Your Ref: 2019/91327
Our Ref: V007233

7th June 2019

Thongsbridge Mills, Miry Lane, Thongsbridge, Holmfirth - Reserved matters application pursuant to outline permission no. 2017/90207 for erection of B1 light industry

749-01-05

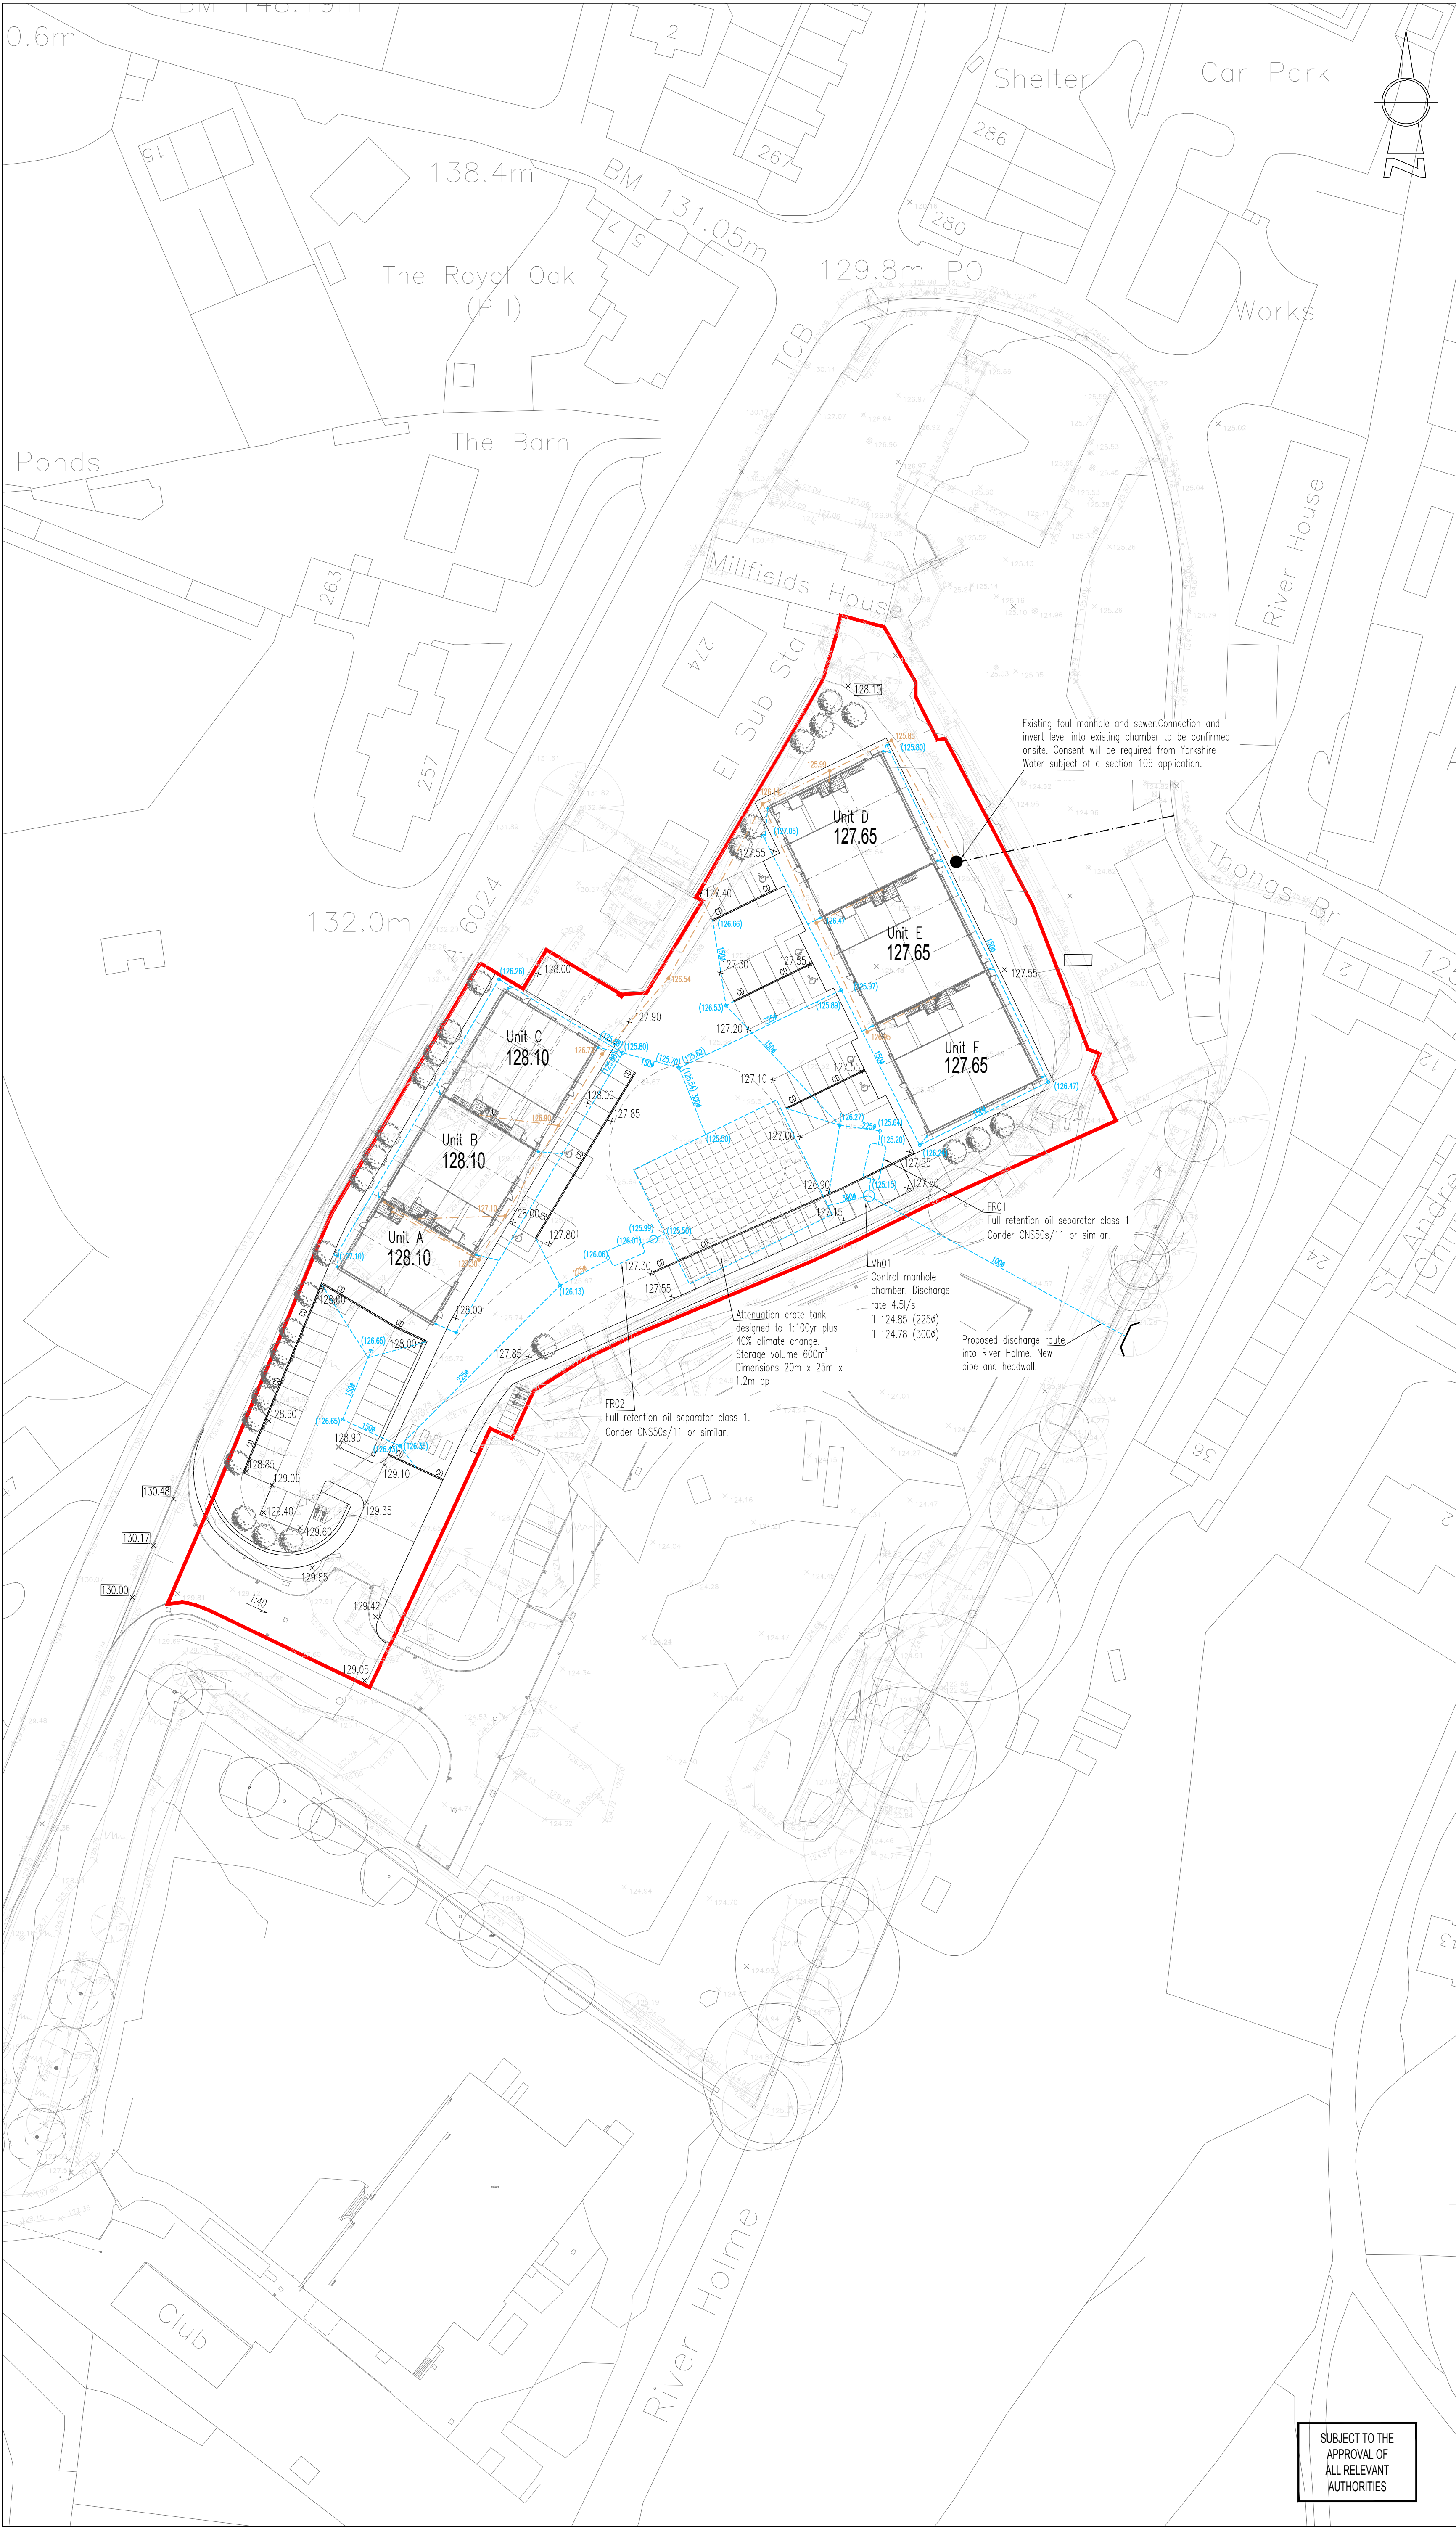
Yorkshire Water has no objection to:

- 1) The proposed separate systems of drainage on site and off site.
- 2) The proposed amount of domestic foul water to be discharged to the public combined sewer network.

submitted on drawing no. 749-01-05 (revision /) dated 22.03.2019 prepared by ARP Associates that also shows surface water proposed to be drained to the watercourse to the east of the site.

Given the above, YW has no further comment on the submitted reserved matters and any relevant drainage conditions imposed on the outline permission can, so far as we are concerned, be discharged.
